Engineers Comments Regarding Surface Water Drainage

Application Reference:	Y/58/26/HH	Reviewer Reference:	ADC/KW/PC
Planning Officer:	Rhiannon Lloyd	Date of Review:	25/9/2026
Site Name:	88 Bilsham Road, Yapton		
Application Description:	Removal of existing conservatory and erection of single storey extension.		
Assessment Number:	1 of 1

Flood Risk Assessment for 88, Bilsham Road, Yapton. BN18 0JY.

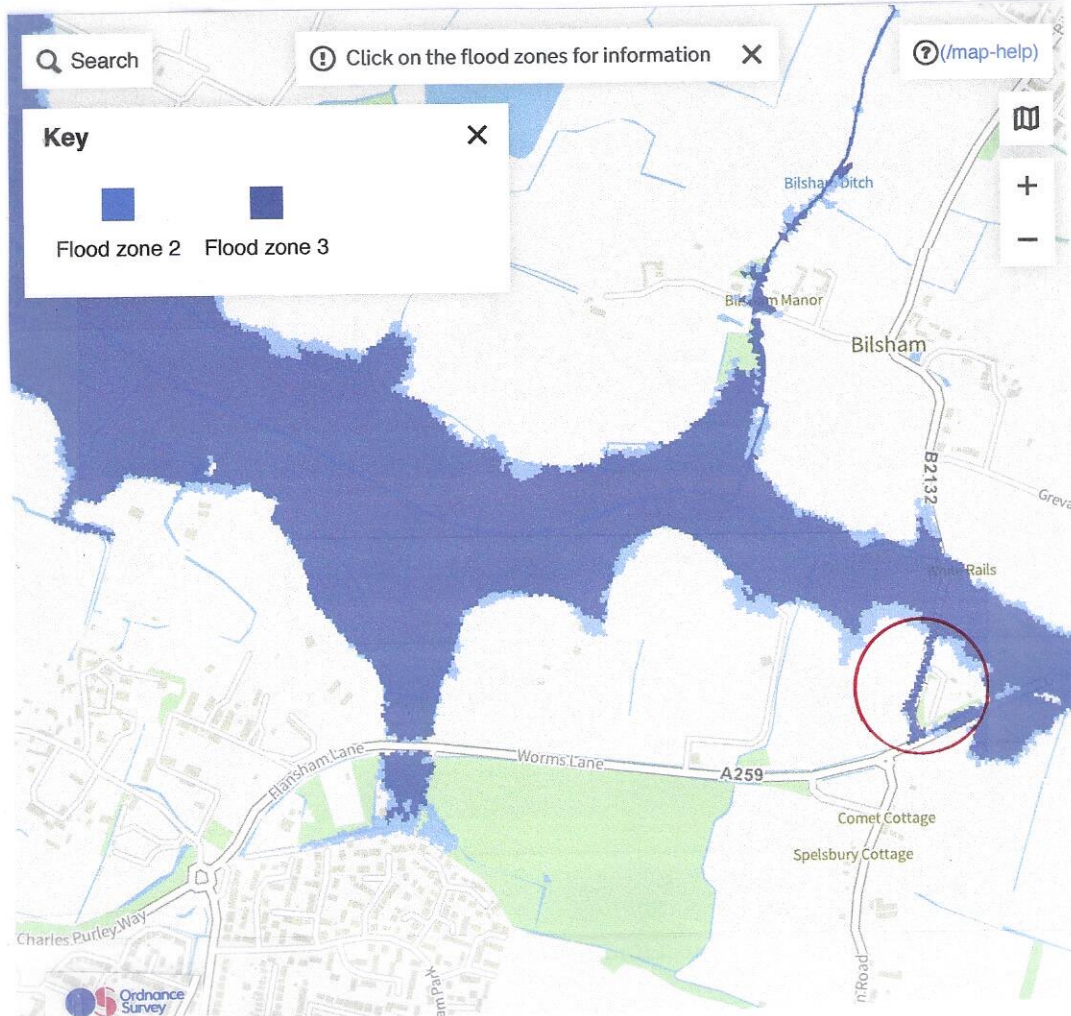
A Flood Risk Assessment has been submitted however an incorrect site has been identified on the plan. The site is currently located within a future Flood Zone. Product 4 data (available from the Environment Agency) is required to identify the source of the flood risk. SuDS features should not be located in fluvial flood zones. (Please see our guidance relating to this at www.arun.gov.uk/surfacewater). Without an accurate understanding of the flood risk on the site, we cannot assess if the proposed drainage strategy is compliant. Therefore, we object to the application.
